Application No: FG/2/21/HH  
Site Address: 3 Sea Drive Ferring BN12 5HD  
Description of works: Erection of a detached garage.

Thank you for your internet representation made on 2nd February 2021 which has been recorded as an objection with the comments as follows:

SITE PLAN 1:500 @ A4

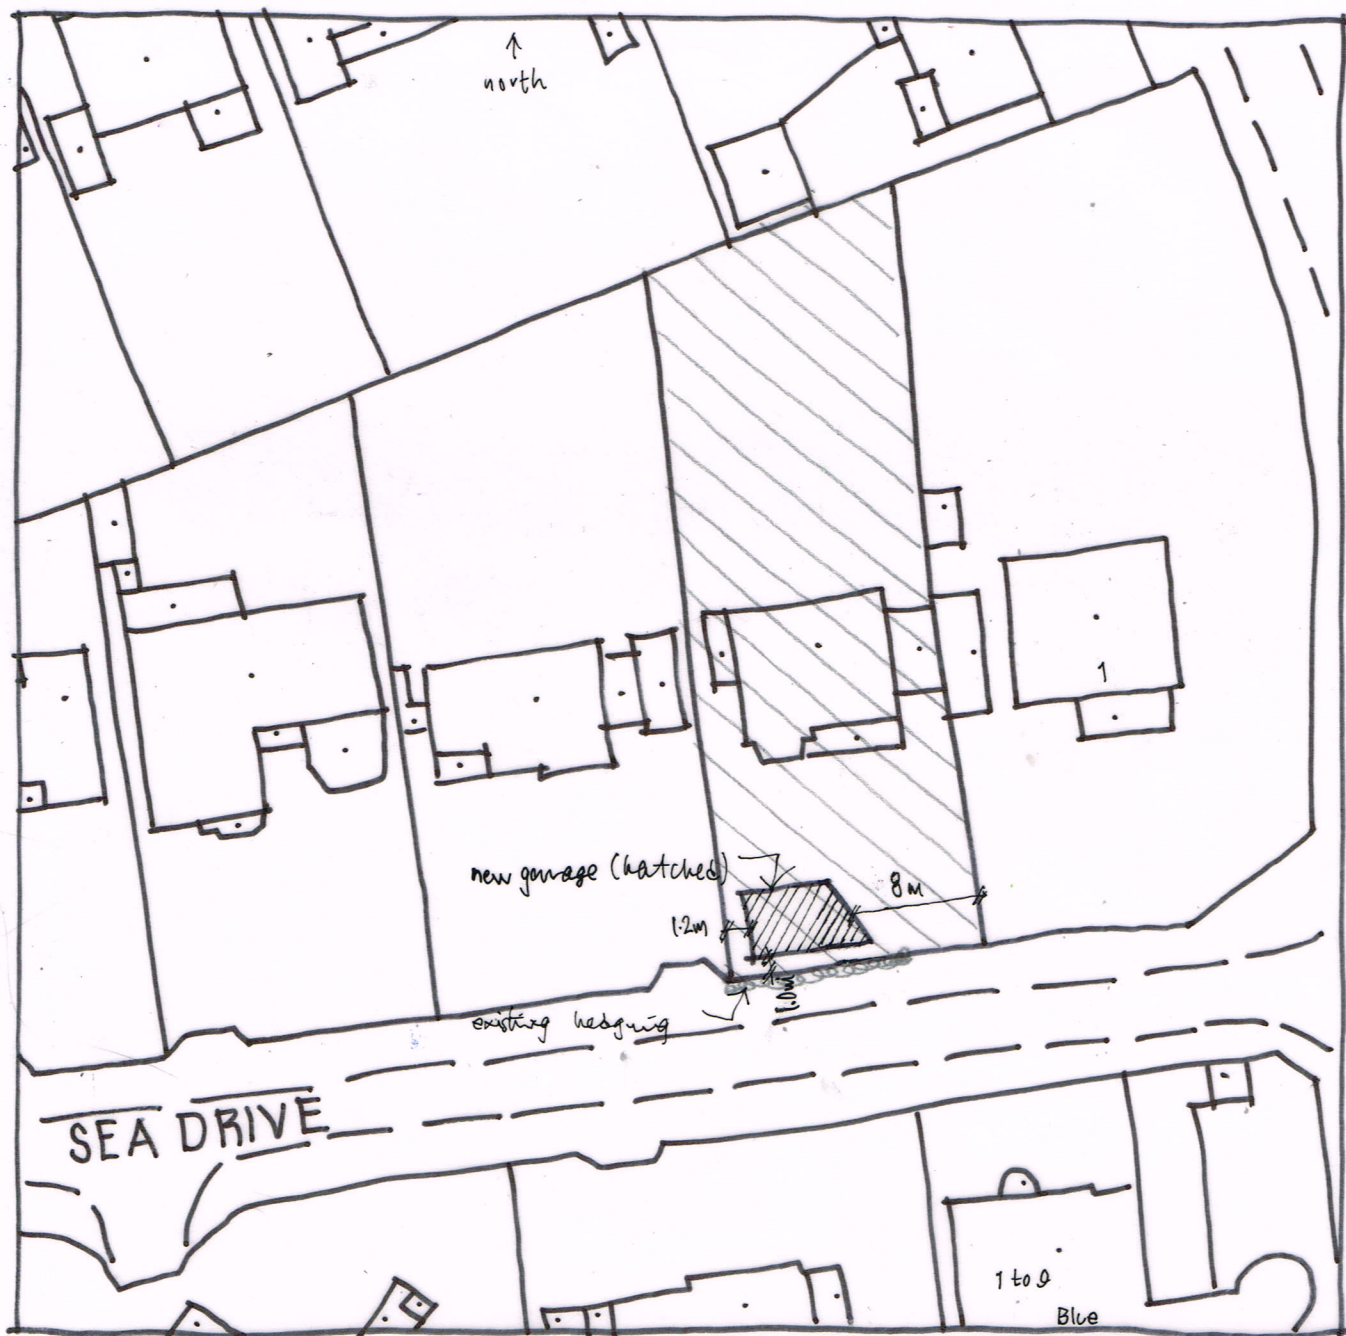
This double garage application is totally out of keeping with Sea Drive. It places a double garage in a front garden in front of the building line. It would be a massive garden infill. Although the garage would currently be concealed by a hedge, if the hedge was taken out in the future it would be exposed and be a detriment to the area. I object strongly.
